# CITY OF PORTLAND BUILDING PERMIT

**PERMIT ID:** 2012-65597

has permission to **space is currently one unit - fit up space for four separate units - move center entrance towards street (Commercial St side) & add two new entrances**

**Dept:** Building      **Status:** Approved w/Conditions      **Reviewer:** Jeanie Bourke      **Approval Date:** 01/11/2013  
**Note:** **Ok to Issue:**

A2.01

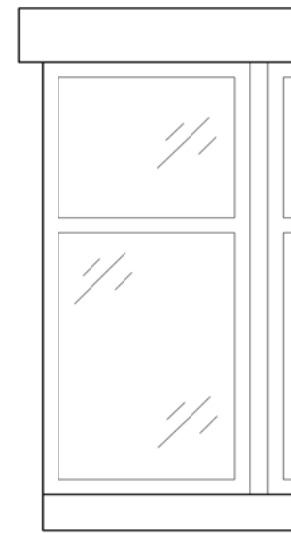
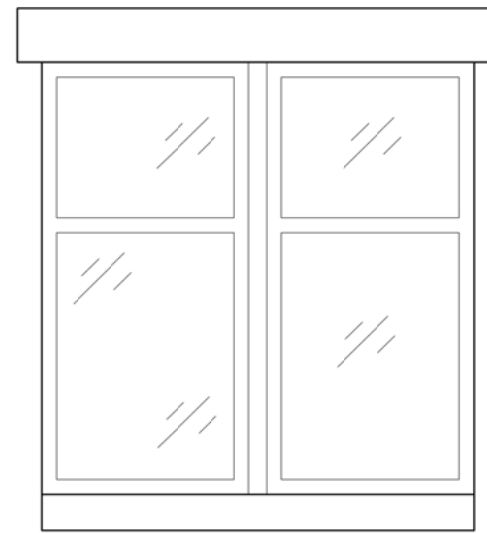
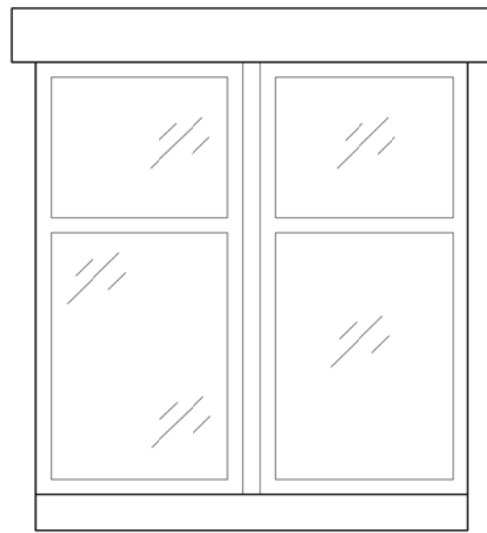
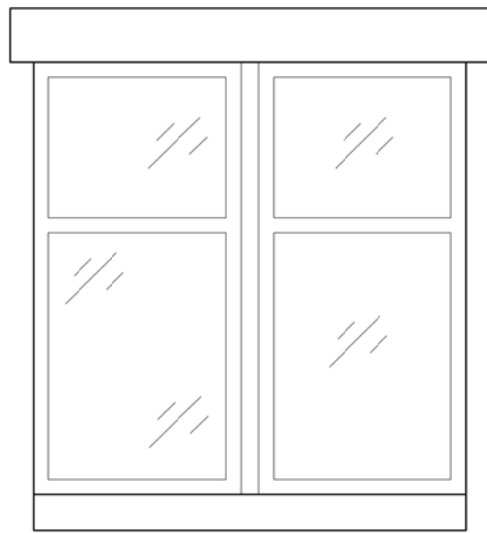
**Dept:** Historic      **Status:** Approved w/Conditions      **Reviewer:** Deb Andrews      **Approval Date:** 12/13/2012  
**Note:** **Ok to Issue:**   
 1) Exterior lighting of projecting blade sign to be integrated with bracket--no independent spot lights or exposed conduit.
